March 13, 2023

Re: Sunrise Grove Apartments – *Technical Review 1*
PA23002

After reviewing the application materials for the above referenced proposal, the Planning Division has the following technical review comments:

SECTION 28, TOWNSHIP 30 NORTH, RANGE 5 EAST, W.M.

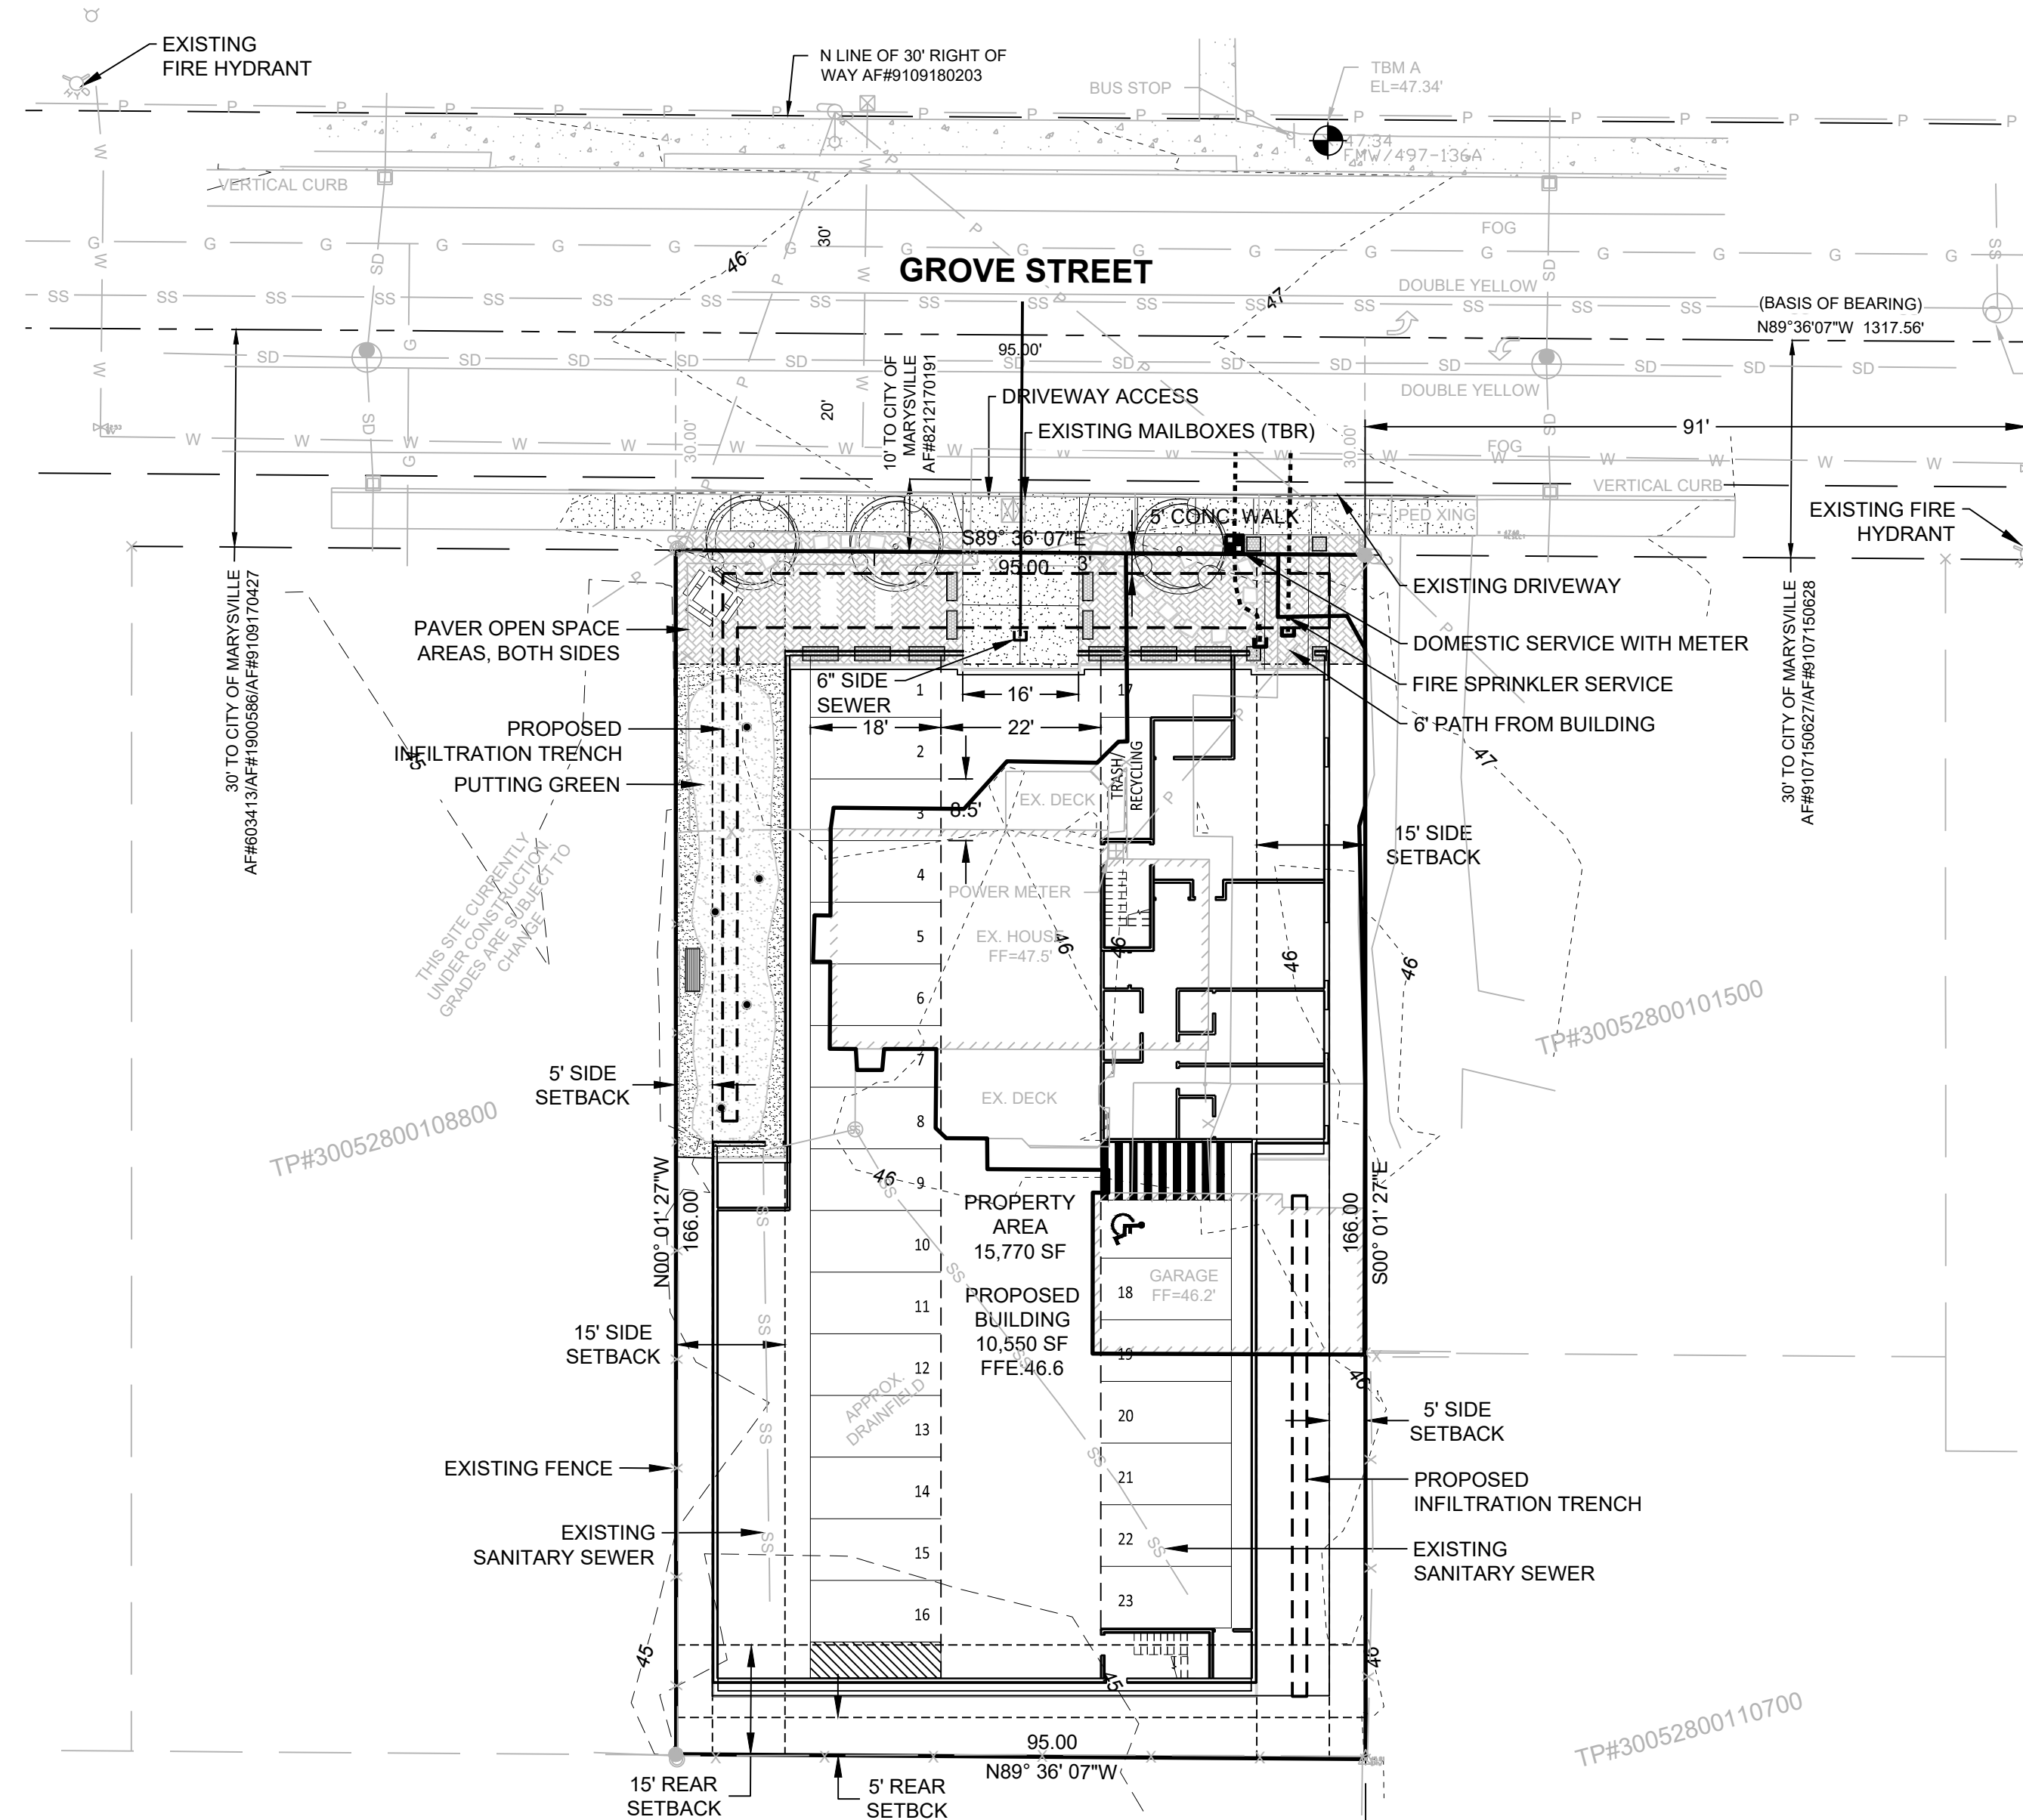
1. Reference File No. PA23002 on all future, site, civil and landscape plan submittals.
2. Amend Sheet P1.0 *Preliminary Site Plan* to include the following information:

- a. Density calculations. The base density if 28 du/acre and the maximum density if 45 du/acre;
 - b. Dimensional standards as outlined in MMC 22C.080.140(2);

- c. Proposed Residential Density Incentives (RDI) to increase the density above 28 du/acre.
 - d. Provide bicycle parking calculations and locations in accordance with MMC 22C.130.060.

3. Parking stalls 1 & 17 do not comply with the 8.5' parking stall width requirement.
4. Provide color elevation drawings, including proposed construction materials, so staff can review compliance with the applicable design standards outlined in MMC Chapter 22C.080.

1 NORTH ELEVATION
1/8" = 1'-0"

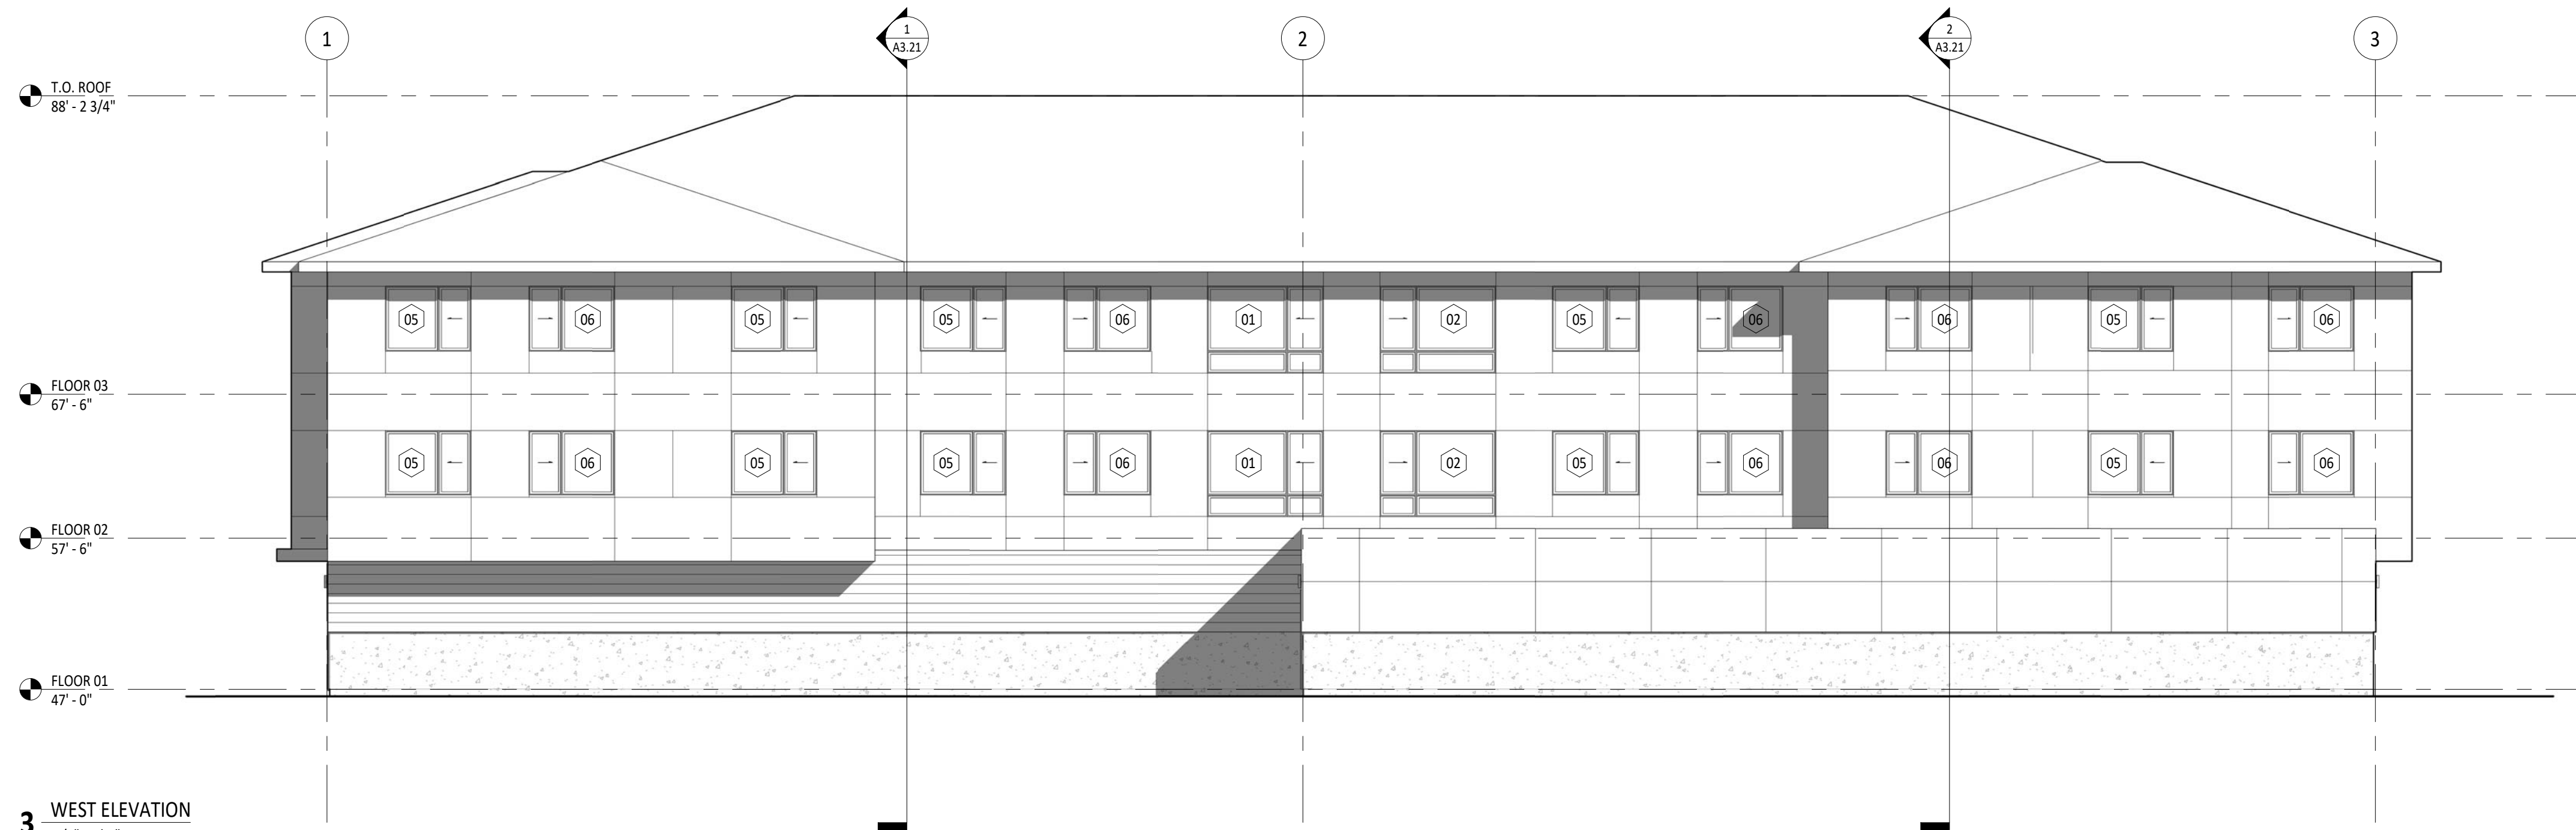
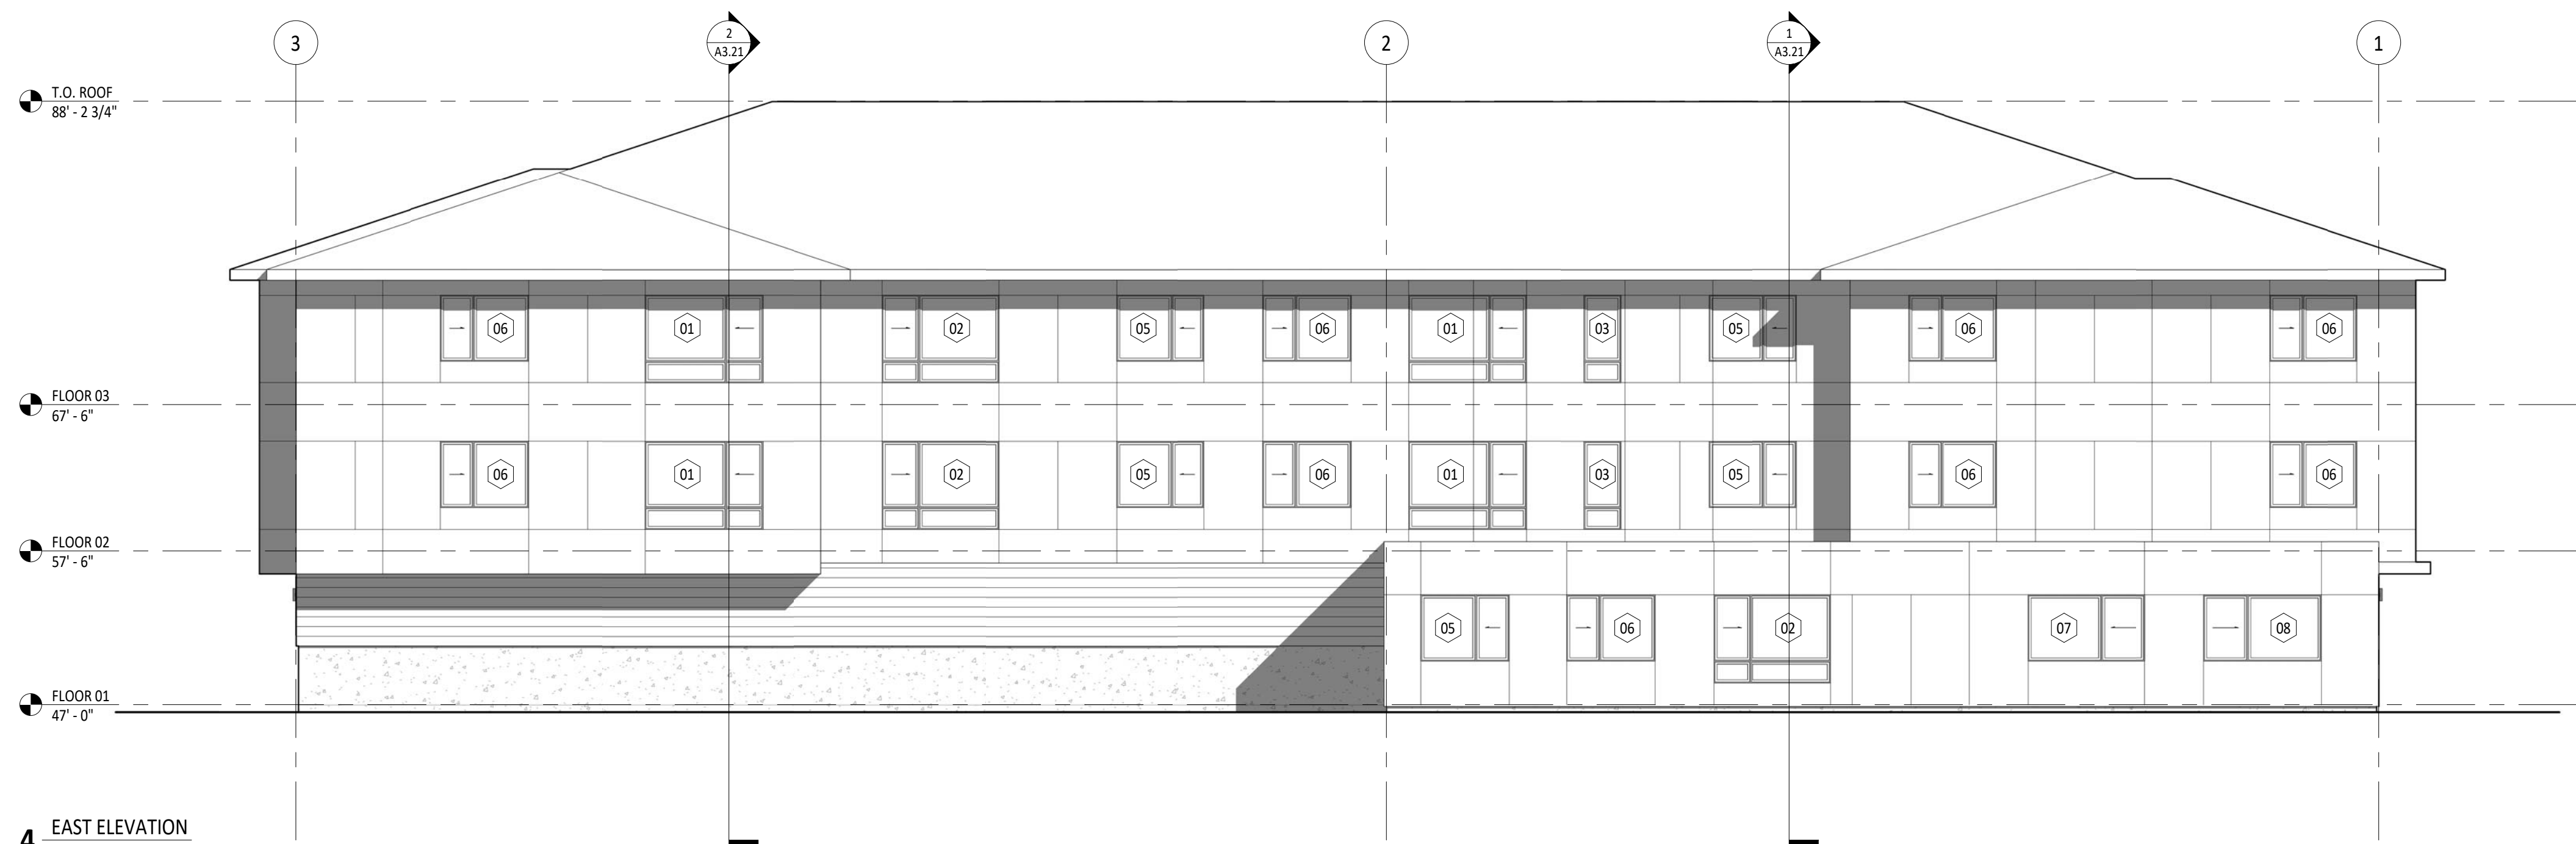
5. A decorative garage door complementing the architecture of the buildings shall be required.
6. Prior to granting occupancy permits CC&Rs shall be required to be recorded with the Snohomish County Auditor, including provisions which address the following:
